**Consultation Response from Emma Mills,
KC Landscape**

Planning Number: 2019/91974

**Proposal: Moldgreen Working Mens Club, 15, Church Street, Moldgreen, Huddersfield,
HD5 9DL**

Demolition of working mens club and erection of 12 apartments

DRAWING TITLE:  
**SITE LAYOUT  
 AS PROPOSED**

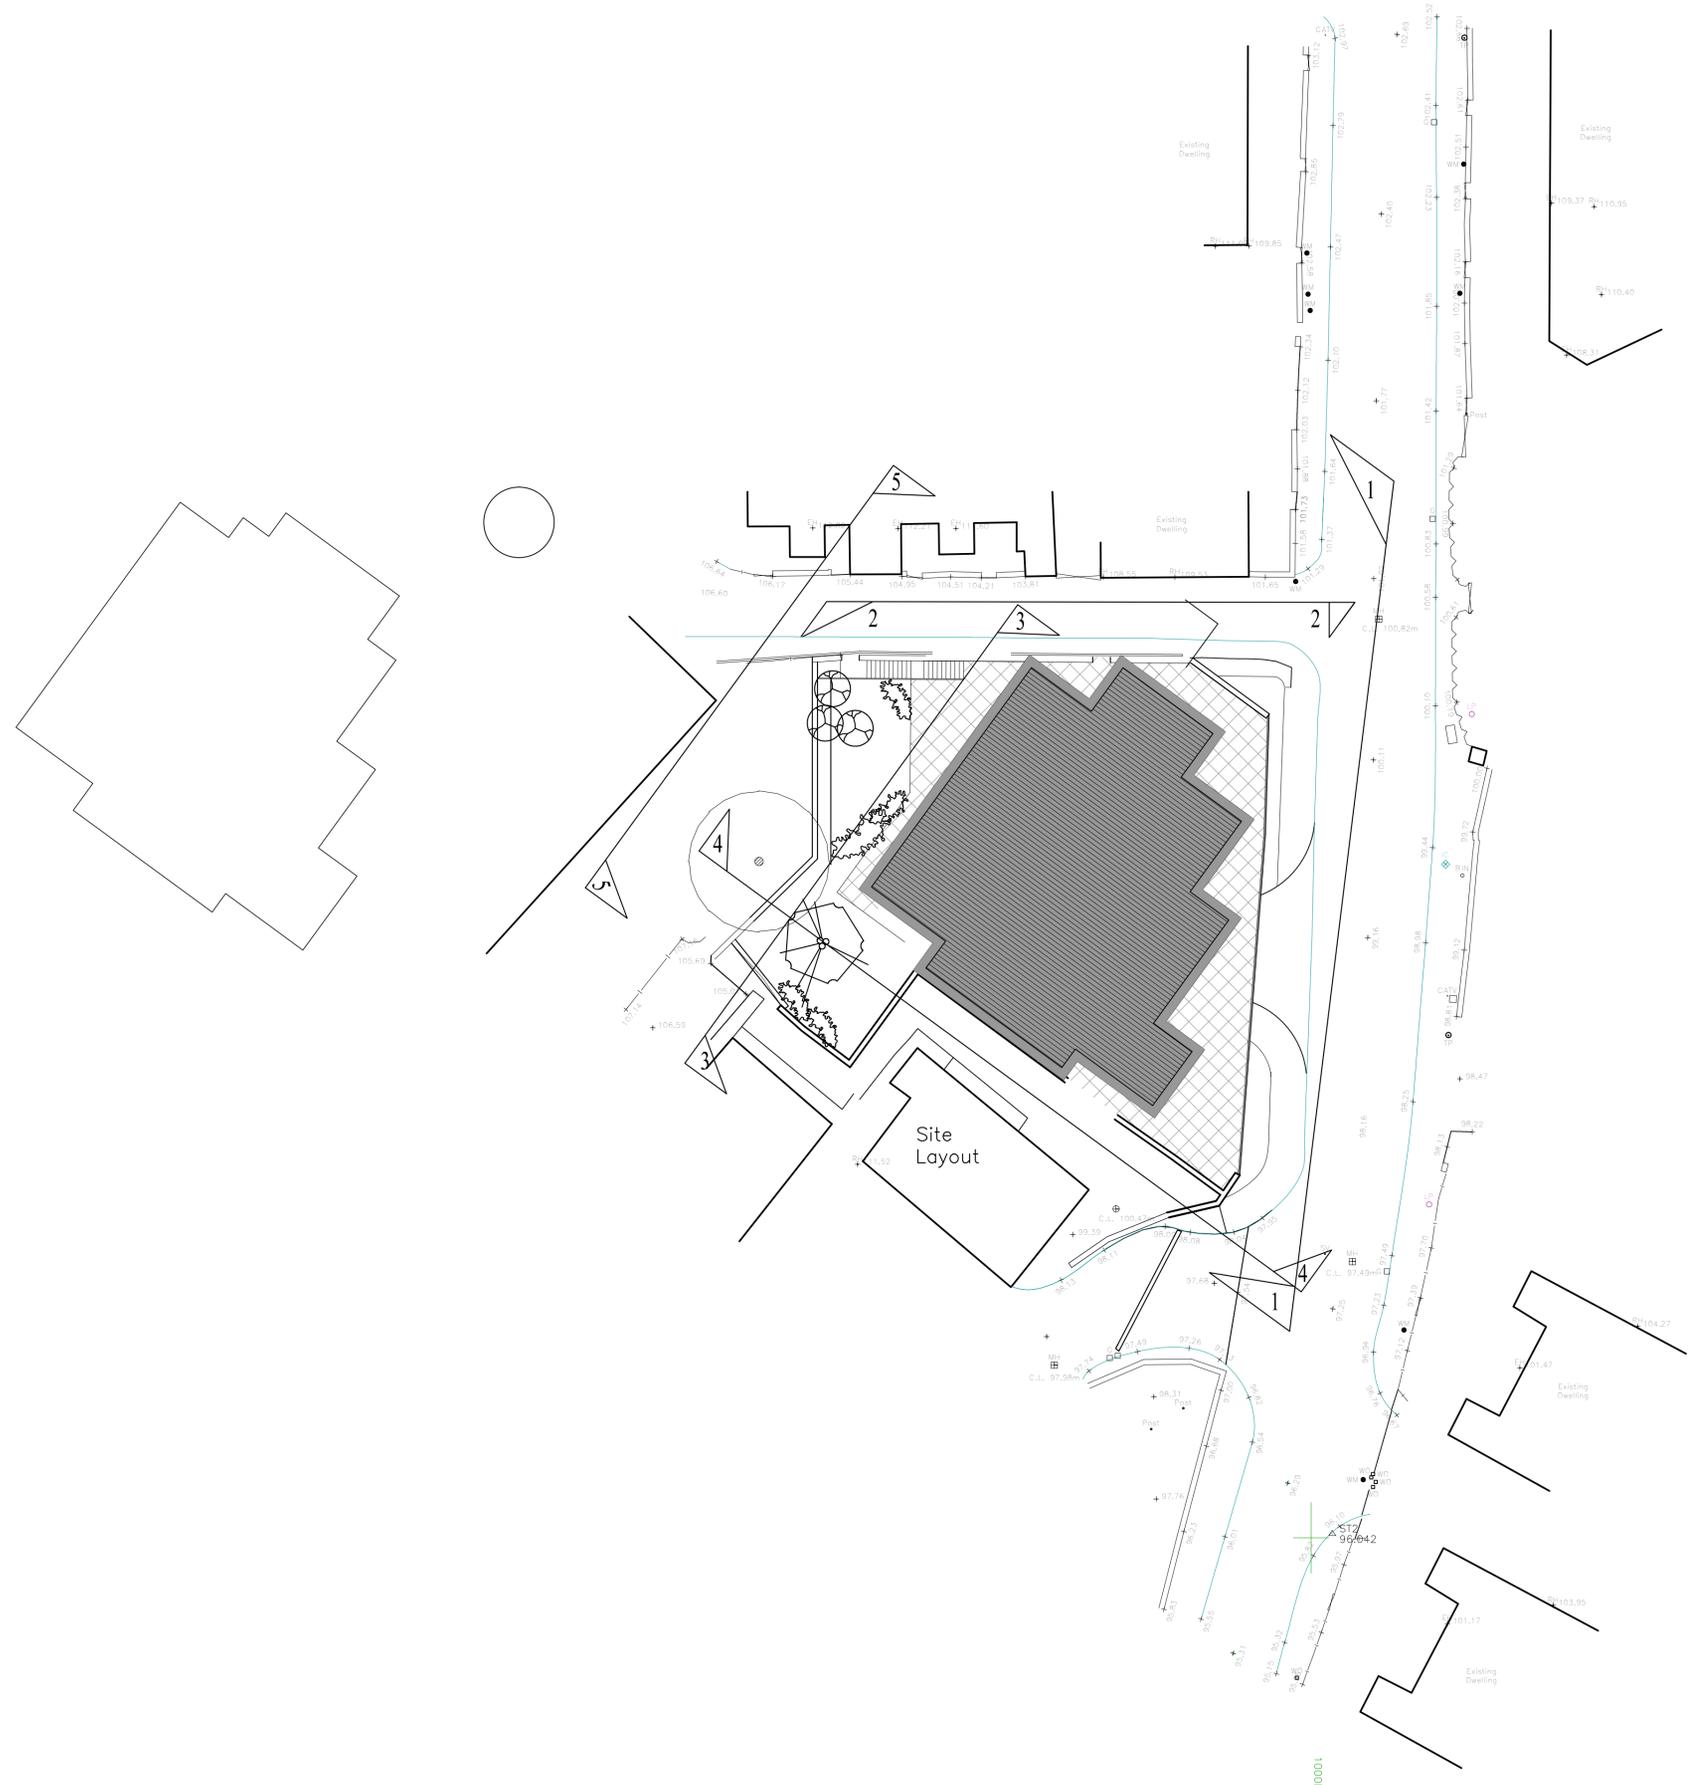
Minimal landscape proposals are shown on the layout application plan and it is difficult to ascertain what the function of the paved areas are- are they being landscaped as amenity areas. Landscape details will need to be provided as per points 1-4 below for further constructive comments. Please provide further details of the refuse areas and bin capacities and access to ensure sufficient capacity for the 12 apartments.

5. The scheme will need to demonstrate clearly where bin storage AND collection points are, each dwelling will require 2 no. containers- at least 1 x 240ltr grey & 1 x green 240ltr and an option for a 3rd brown bin for garden waste. Bin collection points should allow bins to be collected without obstructing the highway, pavements or driveways. It is important that a functional facility for refuse collection is included. Also indicate the location of proposed grit bins.
